CITY OF ALBUQUERQUE
DEVELOPMENT REVIEW BOARD

M I N U T E S

January 15, 2020

Agenda Item 4
Project Number 2019-002184-Site Plan

SITE PLAN - DRB

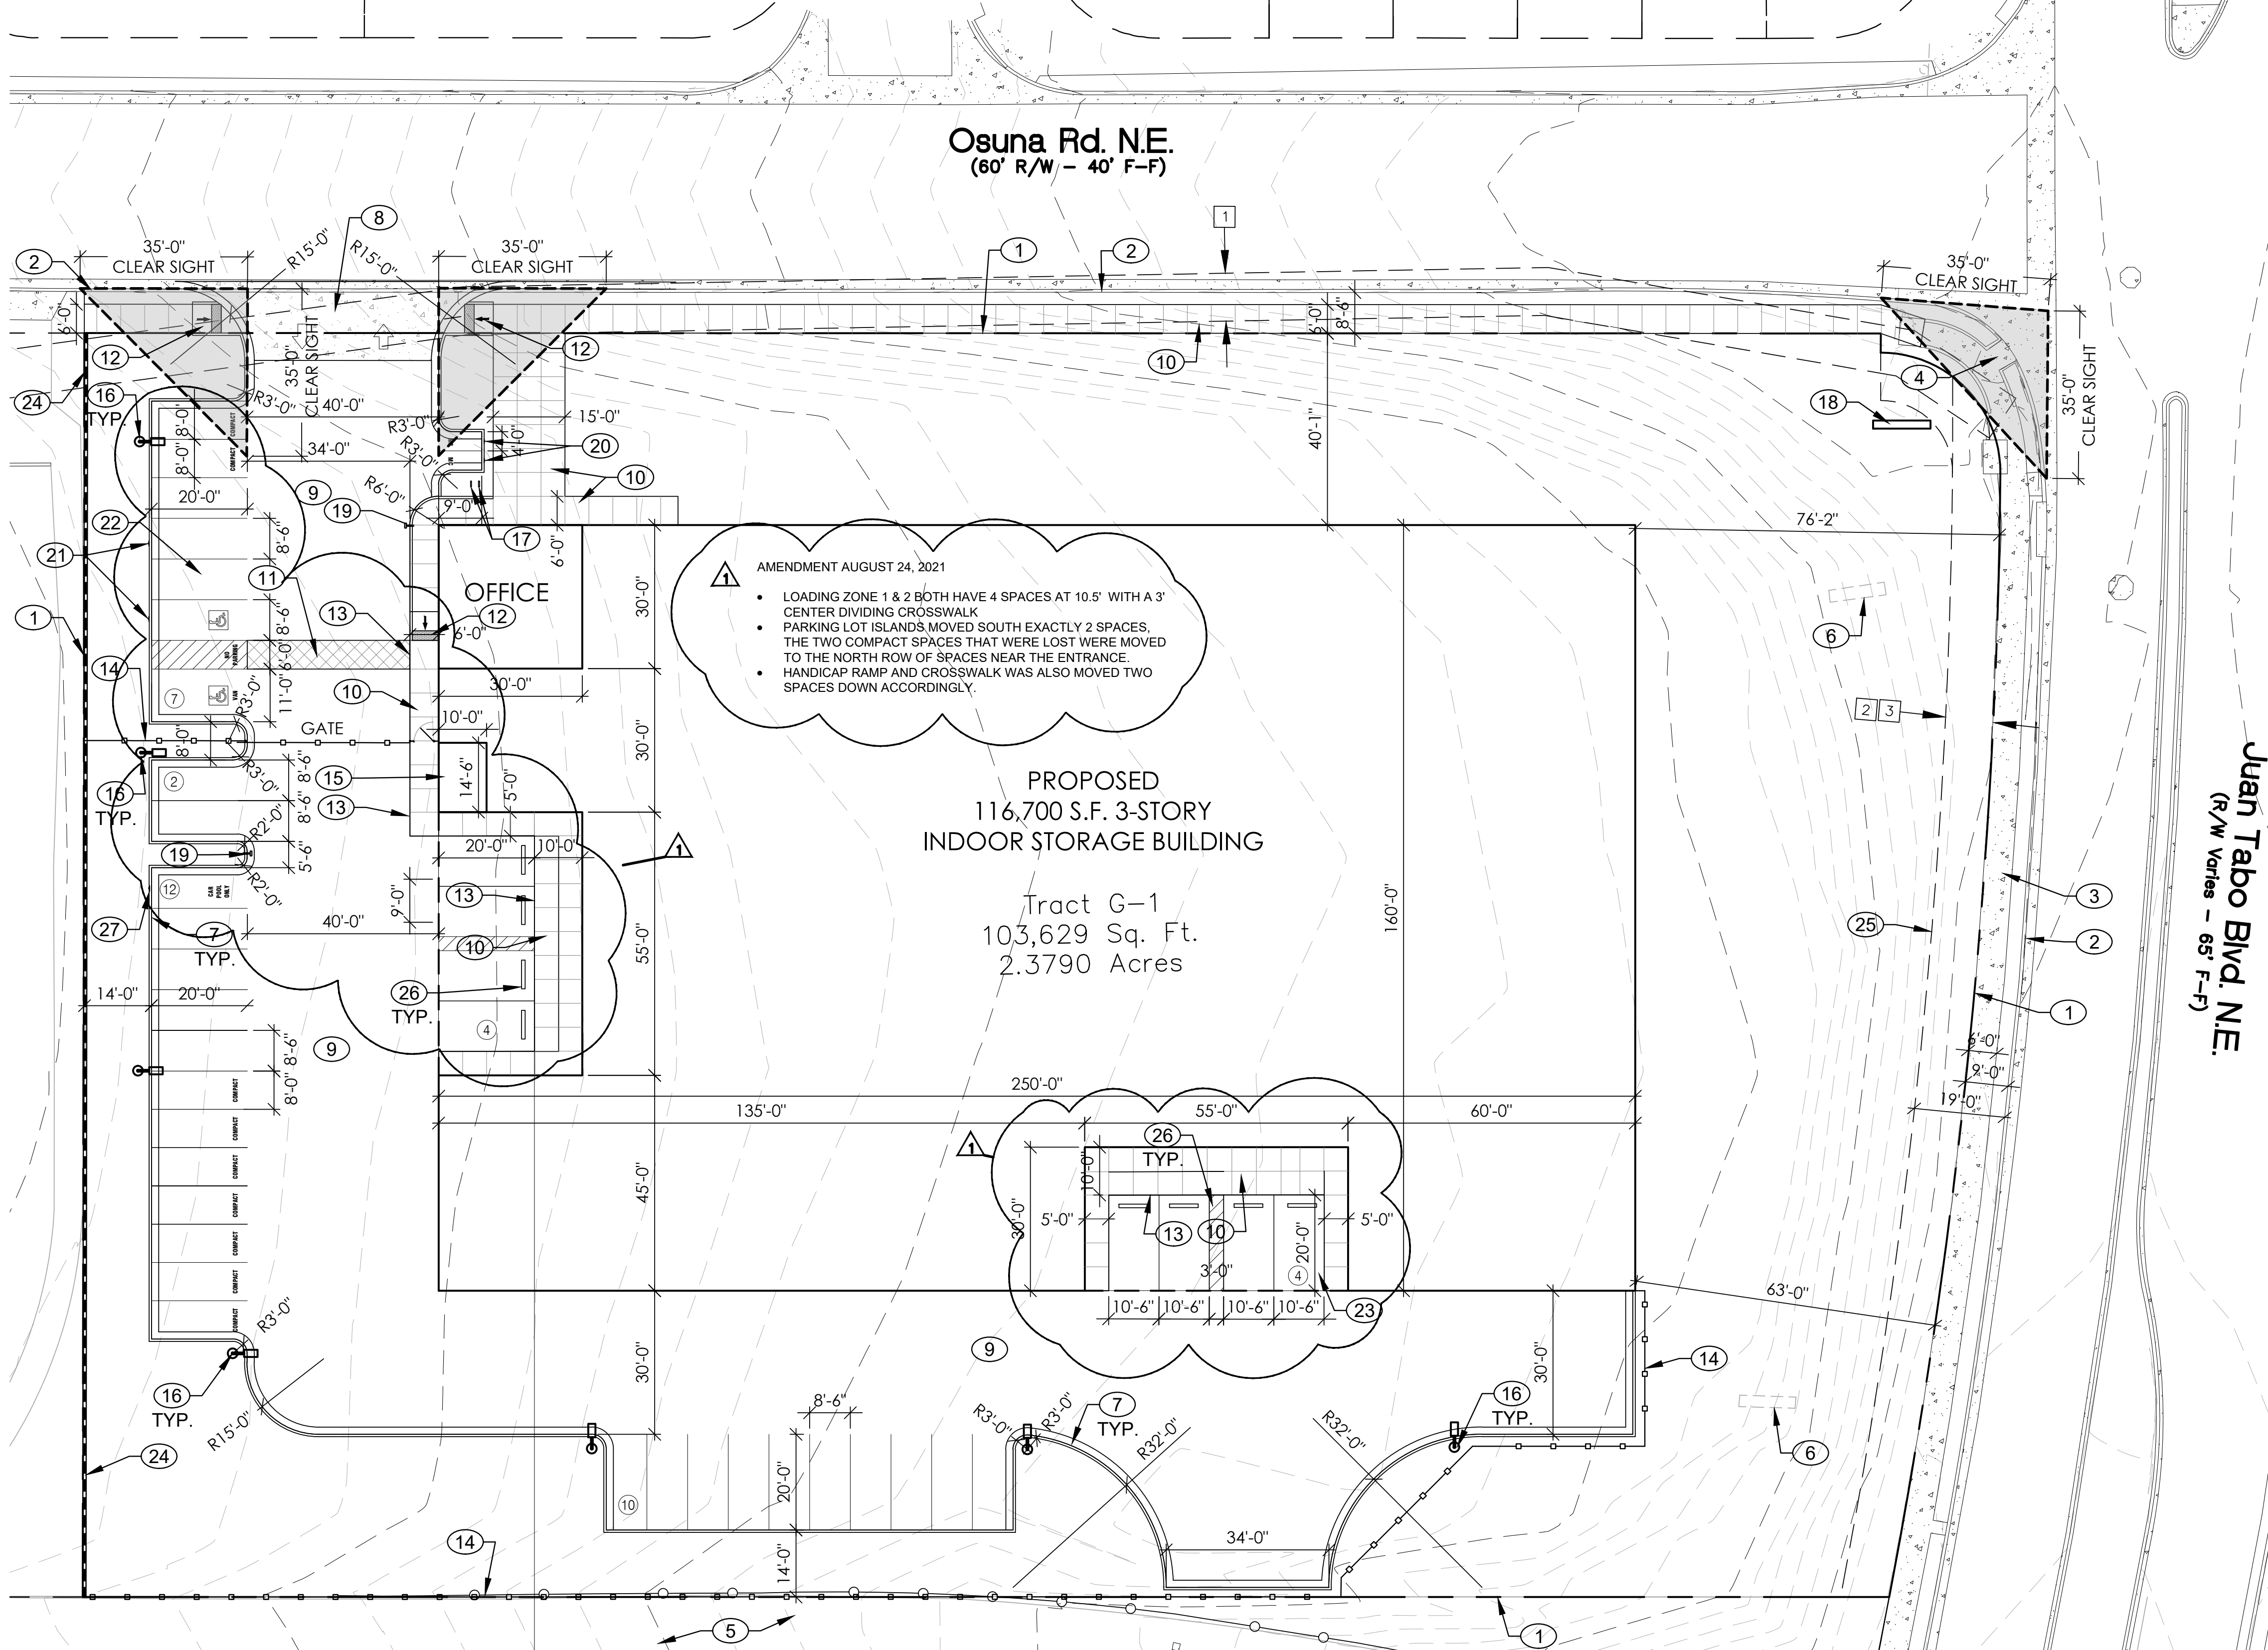
Please, on the site plan, indicate which fire hydrant -- hydrants are public or private. That wasn't -- it wasn't there.

UNIDENTIFIED MALE: Okay. So for -- on the site plan, there's some hydrants, because call out public or private. It looks like that wasn't clarified.

Jim, as we -- you mentioned, we did talk about the opaque wall, and we had a conversation about it. It pretty clear in the IDO that an opaque wall is a "shall" on those properties that are abutting a residential zone

MS. SOMERFELDT: We have no objection. It's just noted that street trees are required on Juan Tabo, which I see there. And that any disturbance to the multi-purpose trail on the -- to the south would be -- it would be required to be remedied by the developer.

SHEET TITLE: CONCEPTUAL DRAINAGE PLAN

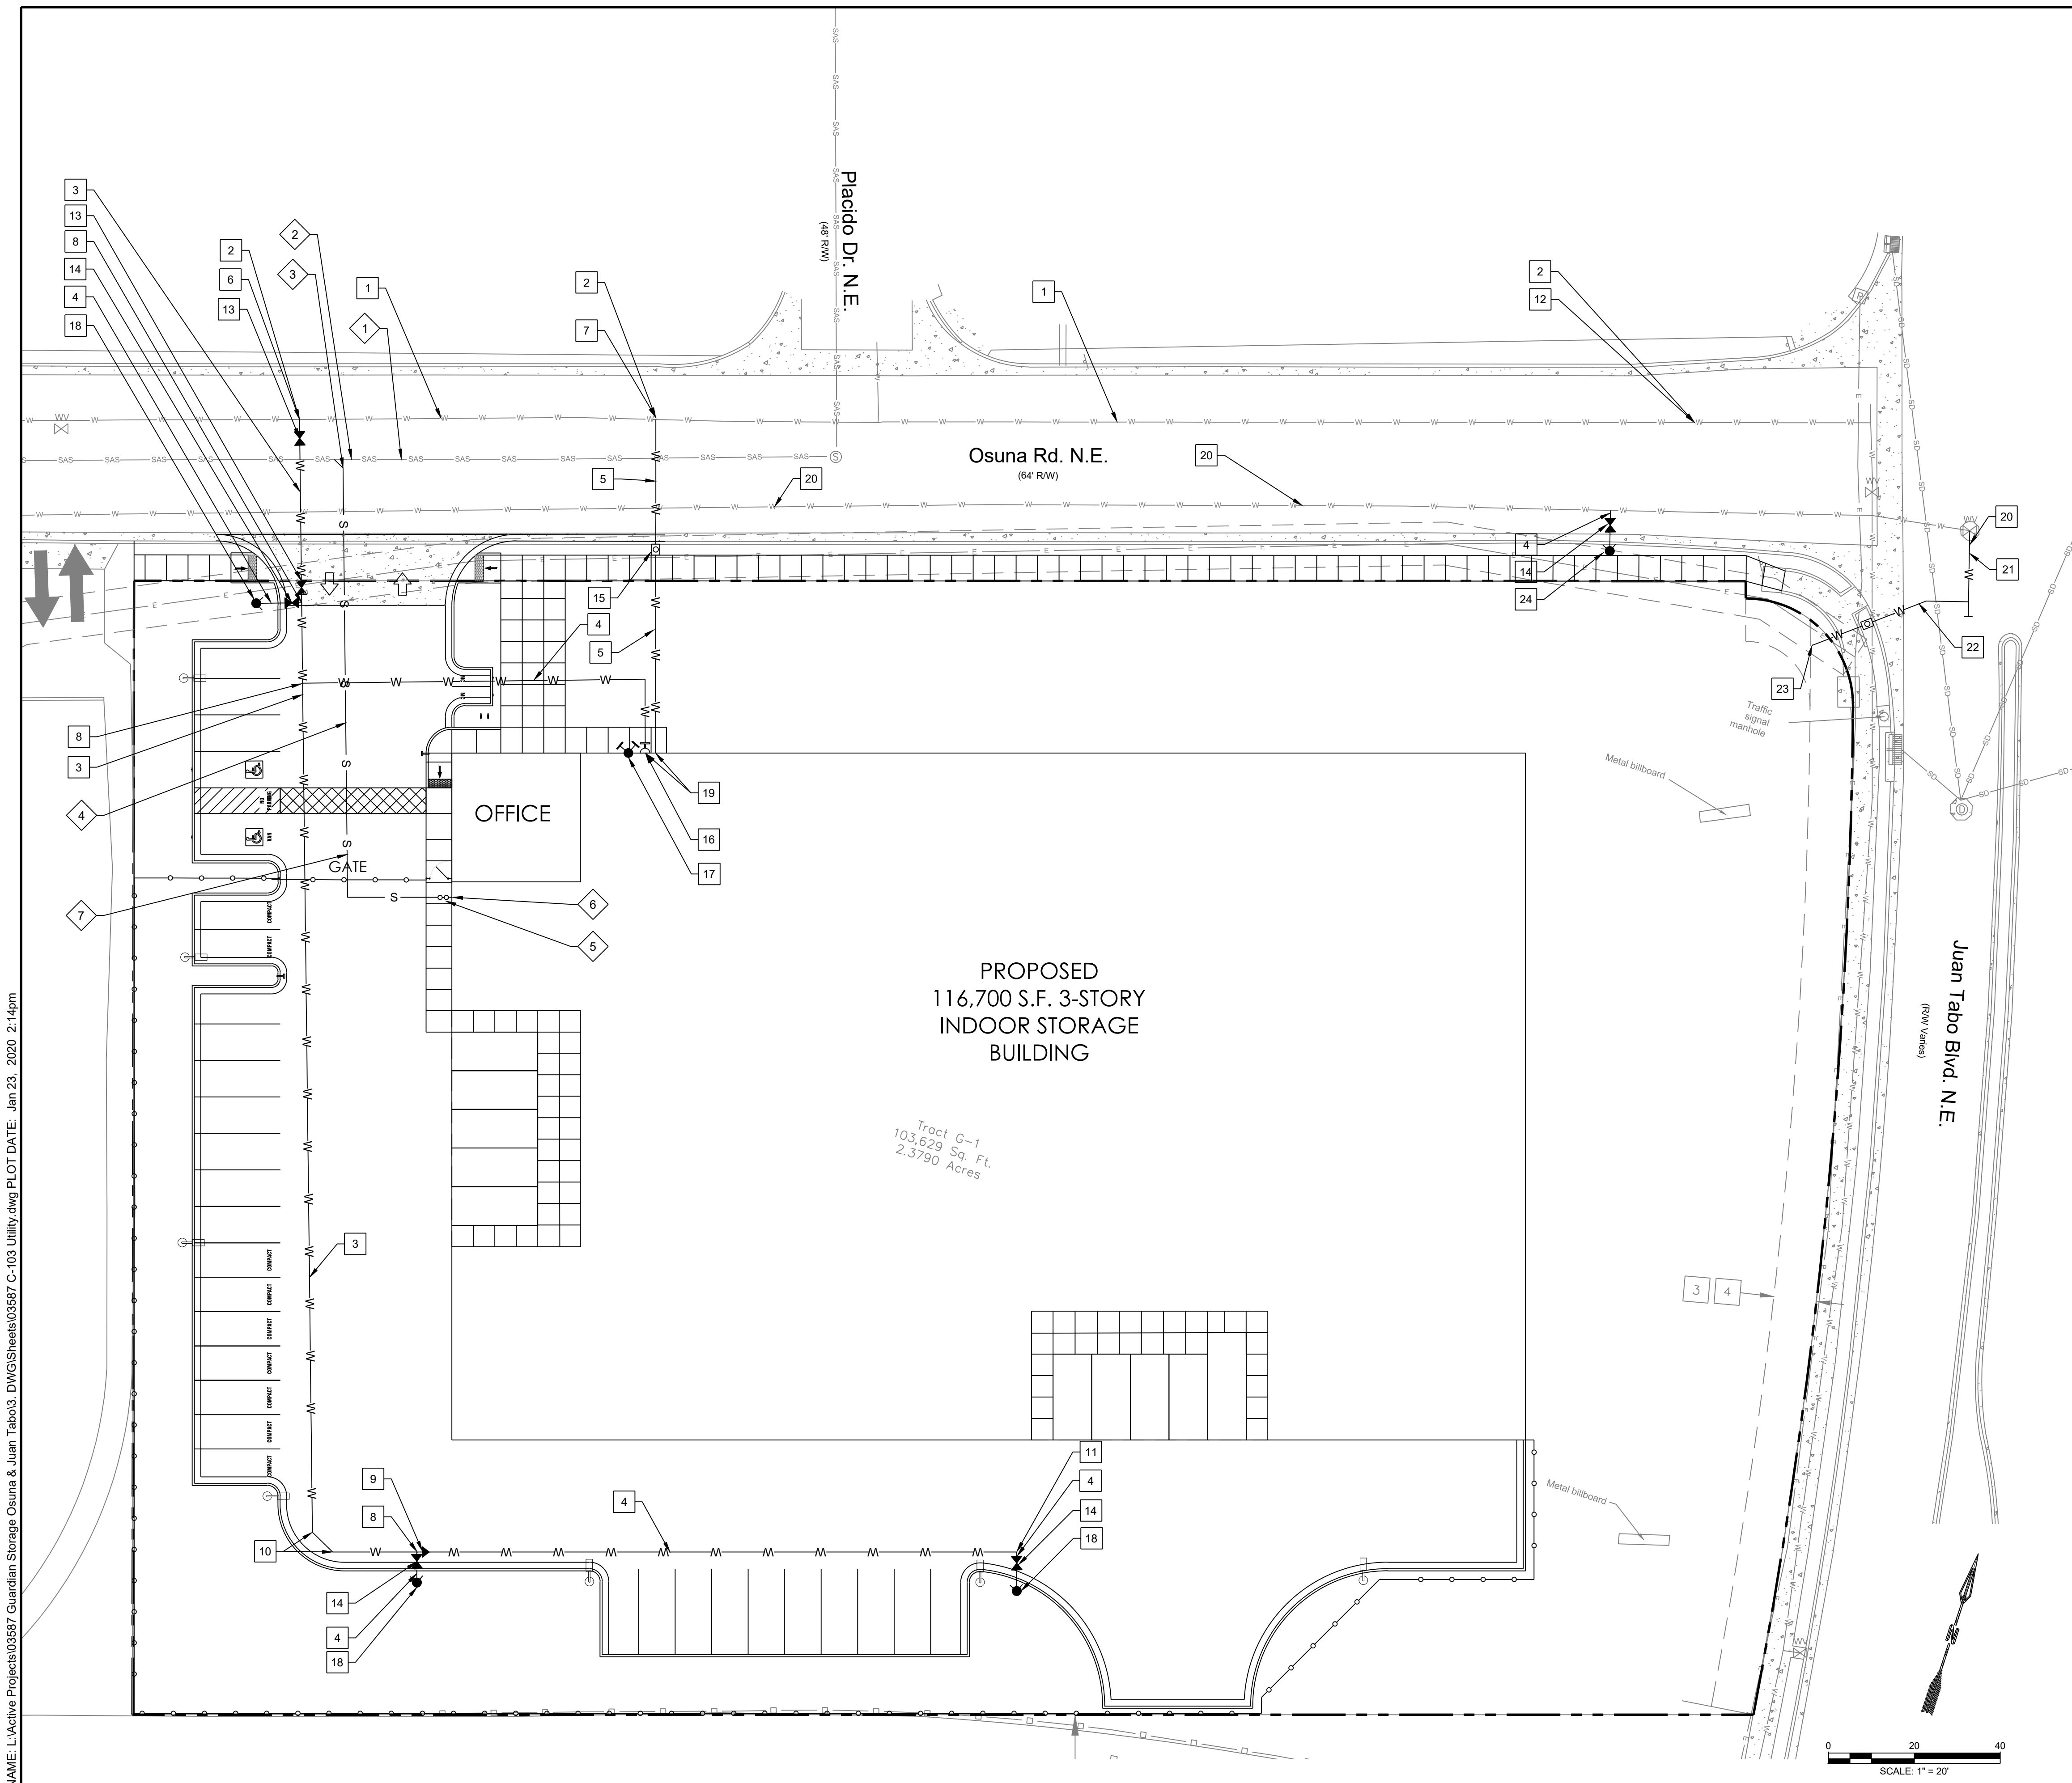
Previous correspondence with the engineer stated historically the site flows were 4.5 for cfs, which some of it historically flowed across the water authority property adjacent. That is now apparently reduced to .29 cfs. We want to confirm that there are will be no erosion issues with you. I don't know what that flow looks like.

MR. LOPEZ: Yeah, no, we -- it's -- the drainage plan kind of spells it out.

MR. LOPEZ: And that's correct, we had -- originally, because of those steep slopes, we did have kind of gravel to protect erosion there --

MR. LOPEZ: -- but with that wall, we might -- at this point, we're not -- we might not even be draining anything into the -- the water authority's property. We're going to be doing a (inaudible) south. And then just for emergency purposes, we'll turn some blocks on that wall in case it ever gets backed up or something, (inaudible), but --

MR. LOPEZ: -- we're not anticipating actually any flows now of water.

SHEET TITLE: **CONCEPTUAL UTILITY PLAN**

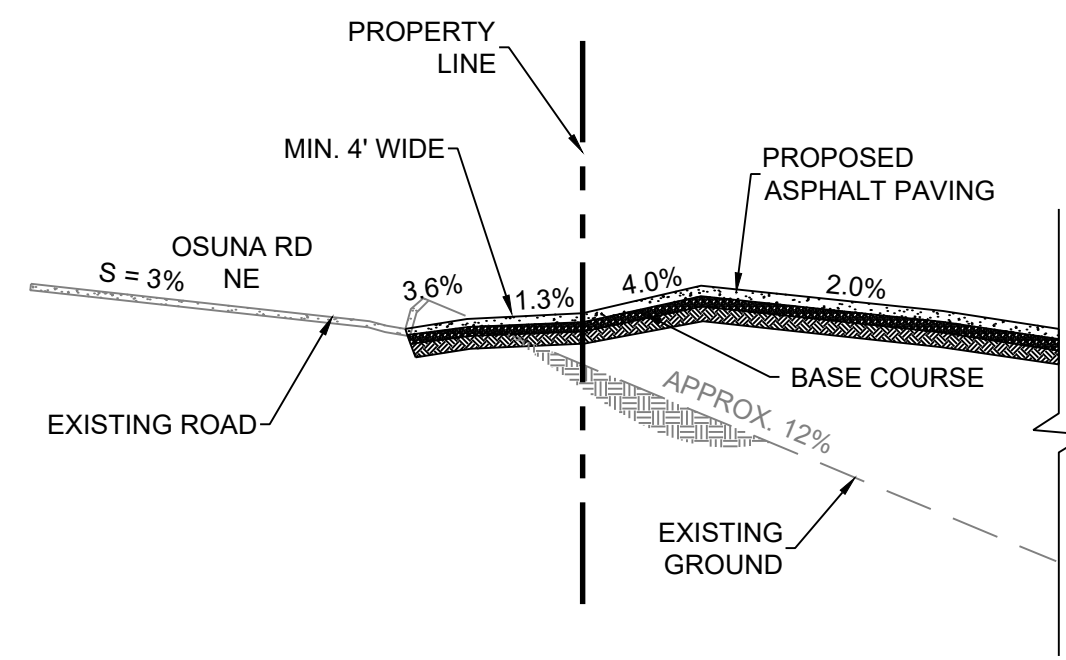
Okay. So like you said, the operation drainage pressure is 106 to 125 psi, so you might need like a pressure reducing. I'm not sure what your system looks like. But when the pump starts, it's up to 150 psi.

Service connection needs to go, I guess, east to Juan Tabo. There's an 8-inch nonpotable line.

UNIDENTIFIED MALE: His comment here is to connect to the 8-inch on Juan Tabo. We don't want to do connections to any 16-inch --
